**Application for Planning Permission for Works or Extension to a Dwelling**

**Development:** Conversion of the existing garage to an annex with minor external alterations to include installation of a window to the rear elevation to the garage facing the house, replacing the garage up and over doors with grey composite cladding accommodating two windows and the entrance door.

**Location:** 7 Meadow Park East Preston BN16 1EG

Synergy Planning & Property Consultants Ltd <small>The Office The Larches Rochester Kent ME3 7NW</small>	
Client Mrs A Sharp	
Address 7 Meadow Park East Preston	
Drawing title Existing survey drawing	
Scale 1:50/1:100/1:200	
Date June 2025	Drawn by
Drawing No 25/474/01	A

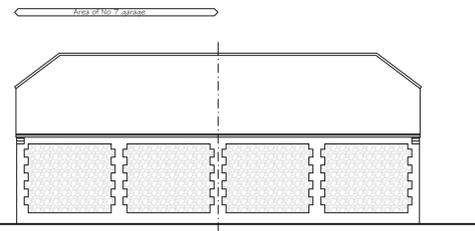
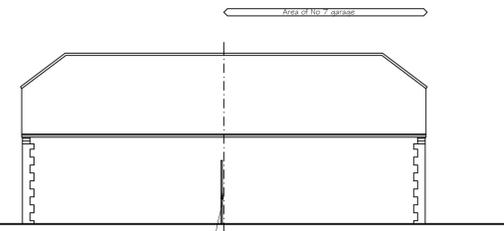
The front and rear elevations have been incorrectly labelled as side and the side elevations have been labelled as front and rear, please review and amend.

Please note, the front elevation is the elevation facing the highway. Further details can be found in the Validation Requirements List.
